PLANNING CONSULTATION RESPONSE

Application No	2026/0324
Proposal	Outline application of access and layout for the erection of 3no. 3-bed dwellings (1no. detached bungalow and 2no. semi-detached dwellings). Appearance, landscaping and scale matters reserved.
Address	10 Clifton Gardens, Brierley, Barnsley, S72 9JZ
Date of Consultation Reply	21 st August 2026
Consultee	Highways DC

[2nd response]

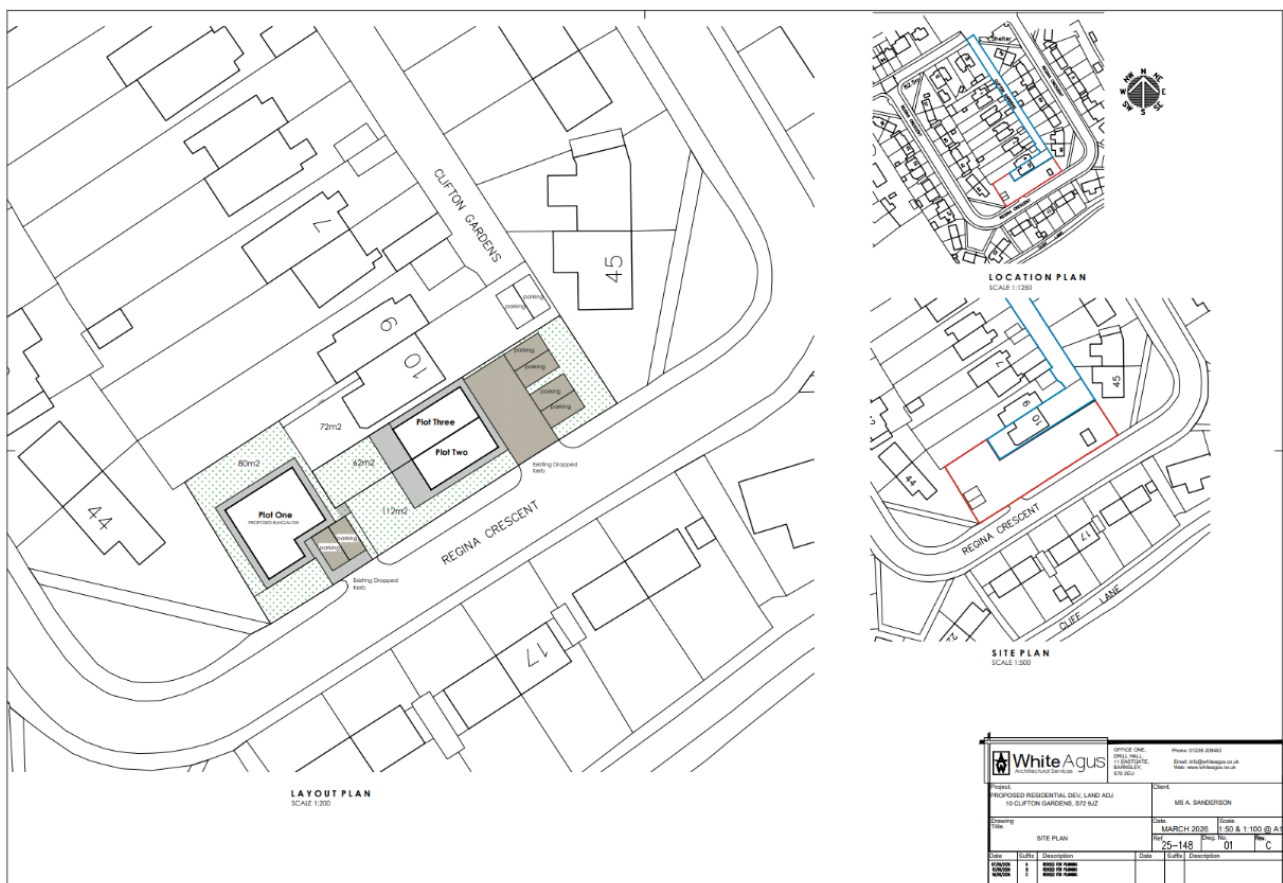
With reference to the amended site plan, the layout now includes two parking spaces within the site curtilage of no.10 Clifton Gardens. However, the spaces appear to be completely inaccessible; the layout plan should clearly demonstrate the point of access for no.10 and show that each space can be properly accessed/egressed.
